1 No. dwelling with detached garage (part resubmission following R/91/17/PL & R/204/18/PL).

Springfield House Springfield Close Rustington

Thank you for your internet representation made on 13th November 2019 which has been recorded as '**an objection**' with the comments as follows:

Job Title	Springfield House		
Client	Castle Property Developments		
Drawing Name	Garage - Plan & Elevations		
Drawing Status	Planning		
Drawn by	DF	Date	Sept 19
Checked by		Date	
Drawing Scale	1:50 & 1:100 at A1		
Drawing No	Status	Revision	
181303/	09

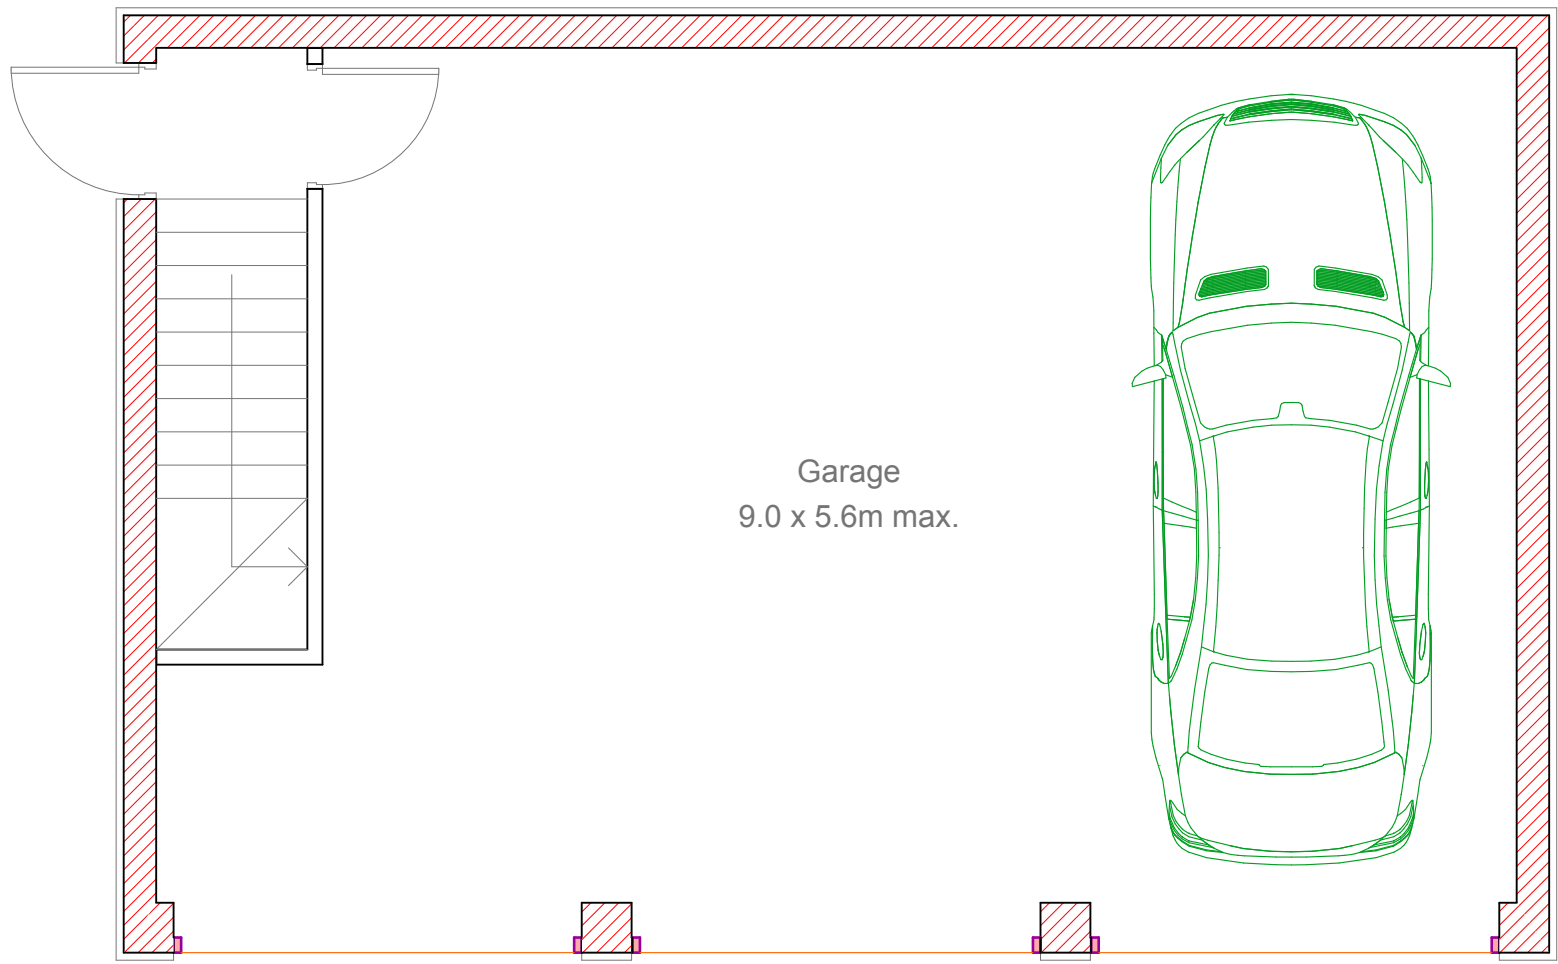
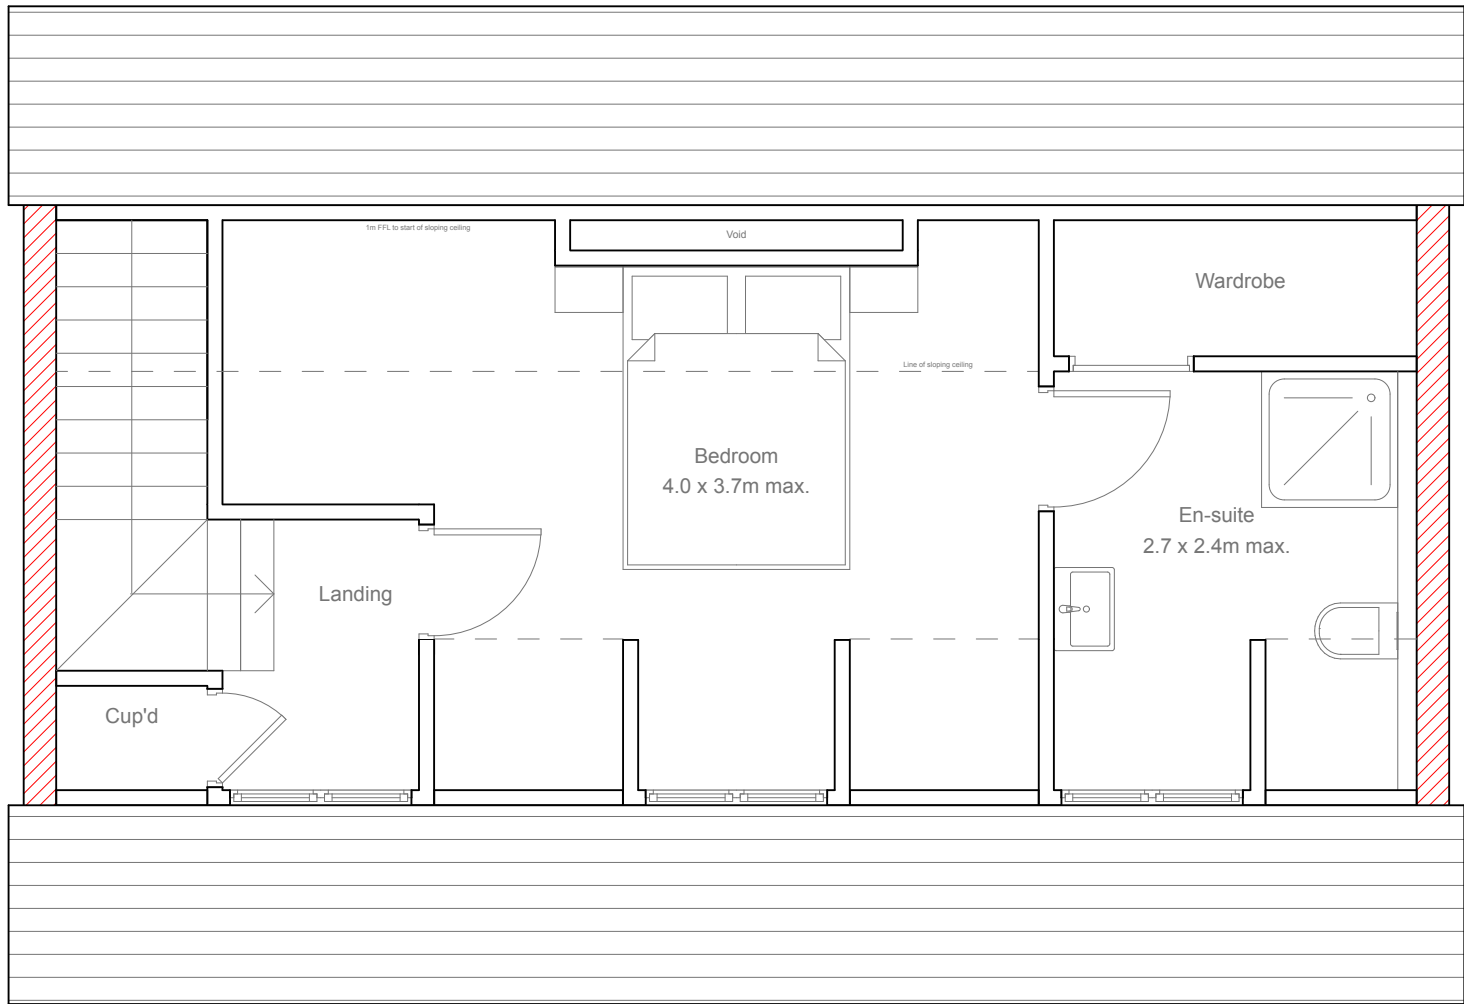
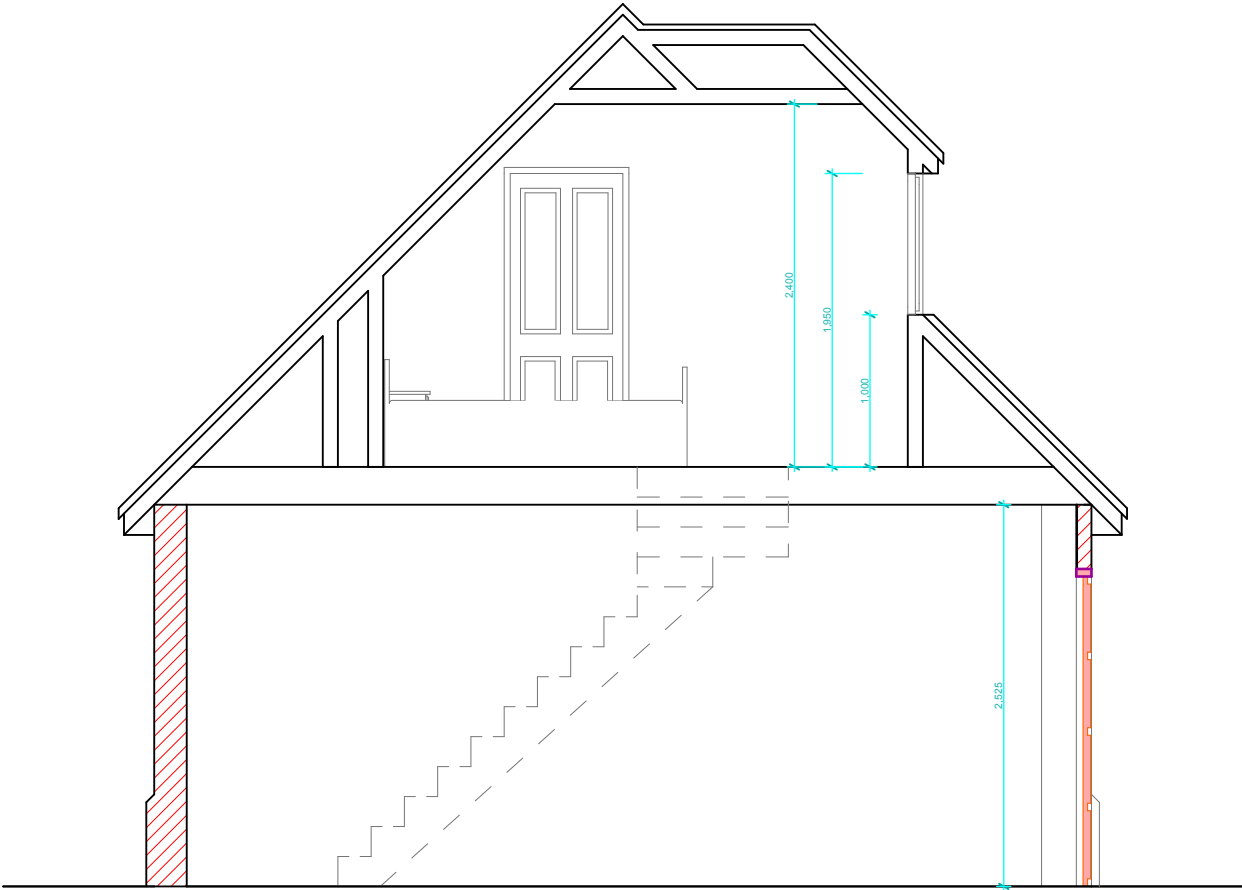
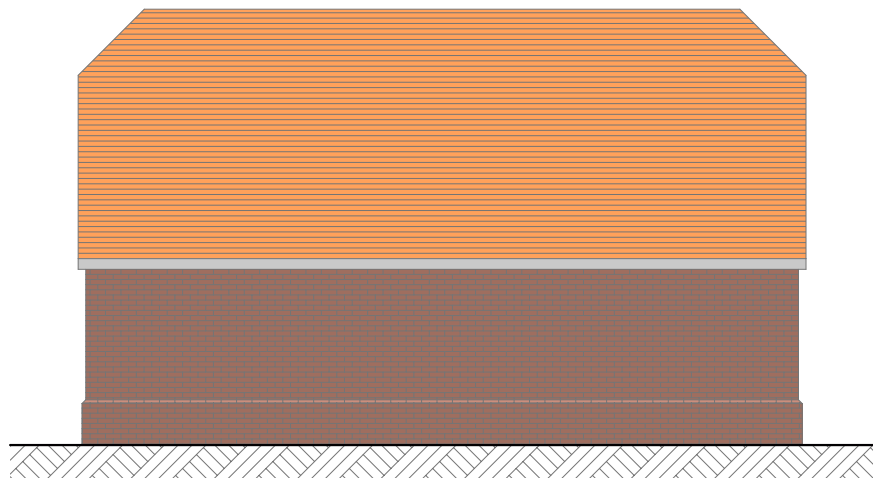
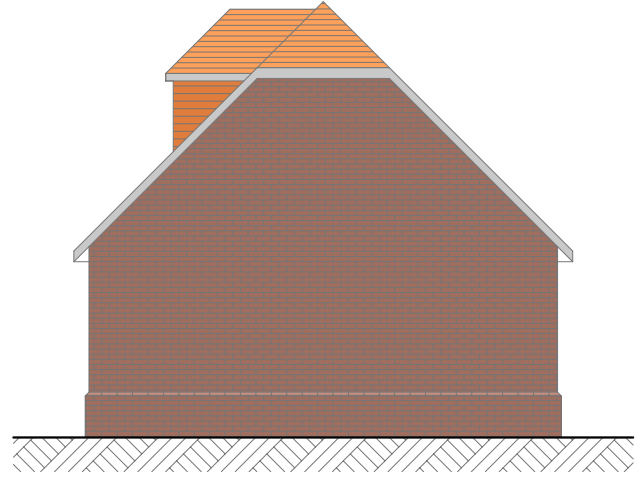
The original plans showed a double garage, this has now changed to a triple garage with accommodation above. This can only add to the negative impact upon our privacy and the privacy of neighbouring properties especially if the trees are removed and not replaced by trees of a similar height and density.
